Application for a non-material amendment following a grant of planning permission.  
Town and Country Planning Act 1990

APPROVAL FOR INSTALLATION OF ADDITIONAL WINDOW ON  
WEST ELEVATION.

20/AB/102 & 20/AB/105

20/AB/102/A & 20/AB/105/B.

No 8 DRAKE PARK
ELEVATIONS

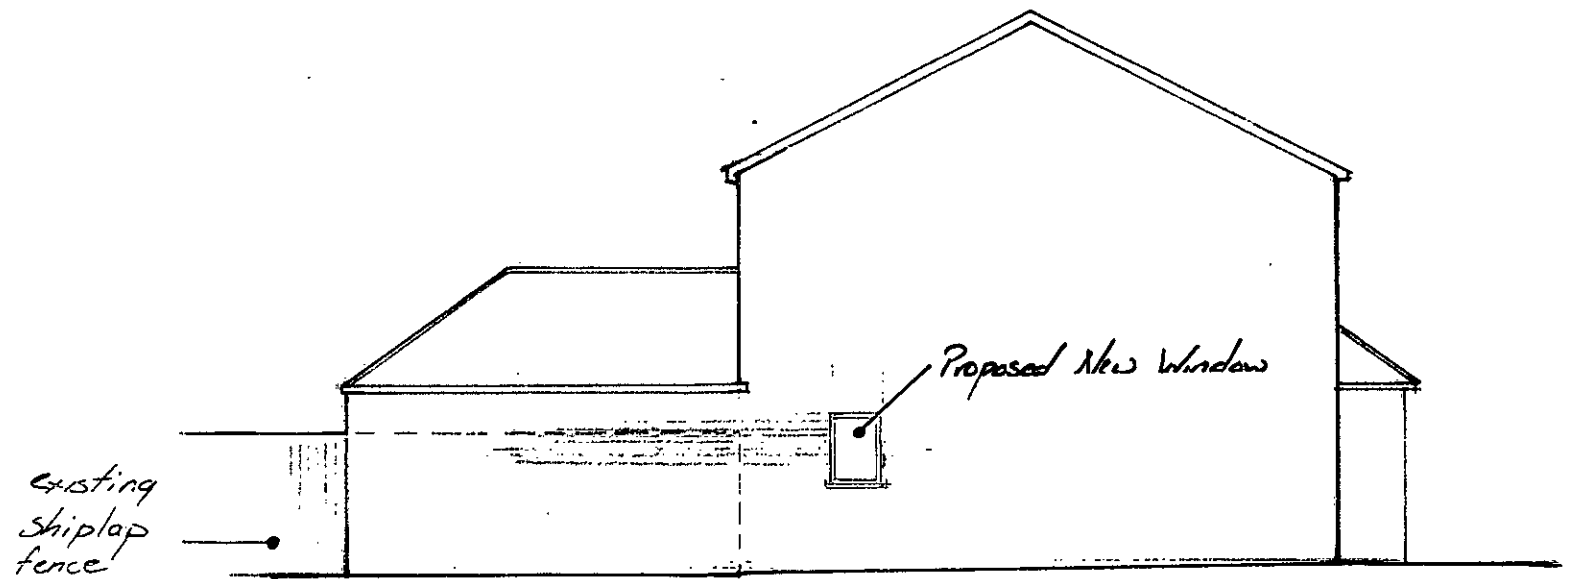
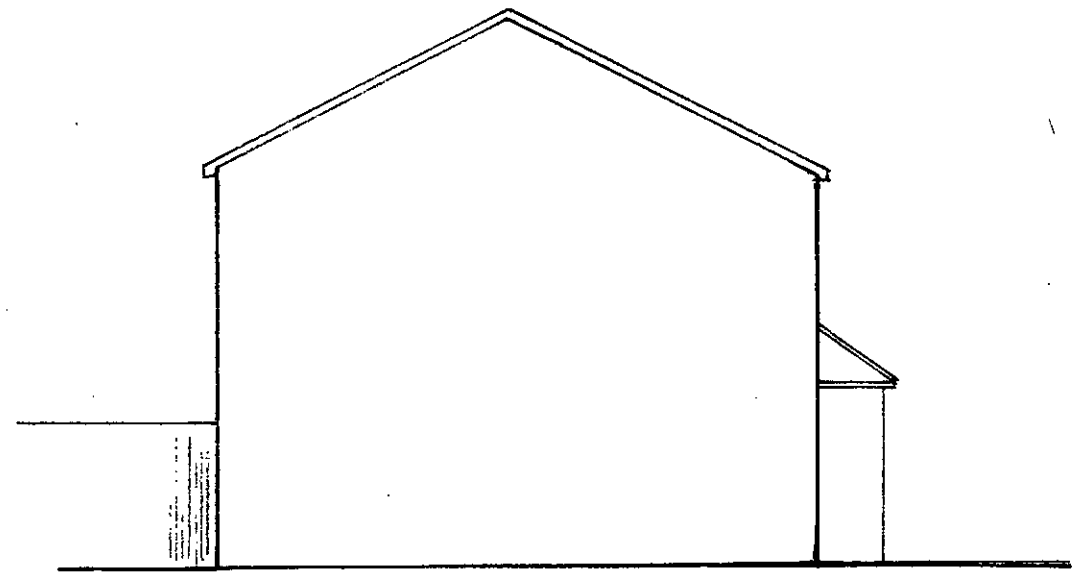
INSTALLATION OF A 900mm high by 700mm wide uPVC WINDOW  
CENTRALLY WITHIN THE WEST WALL OF THE EXISTING KITCHEN  
TO PROVIDE ADDITIONAL NATURAL DAYLIGHT TO THE NEW EXTENSION.

PROVISION OF ADDITIONAL LIGHT. OWNER HAS DECIDED TO REPLAN  
KITCHEN FOLLOWING CONSTRUCTION OF NEW EXTENSION WHICH  
ALLOWS INSTALLATION OF PROPOSED WINDOW AS PART OF NEW  
DESIGN.
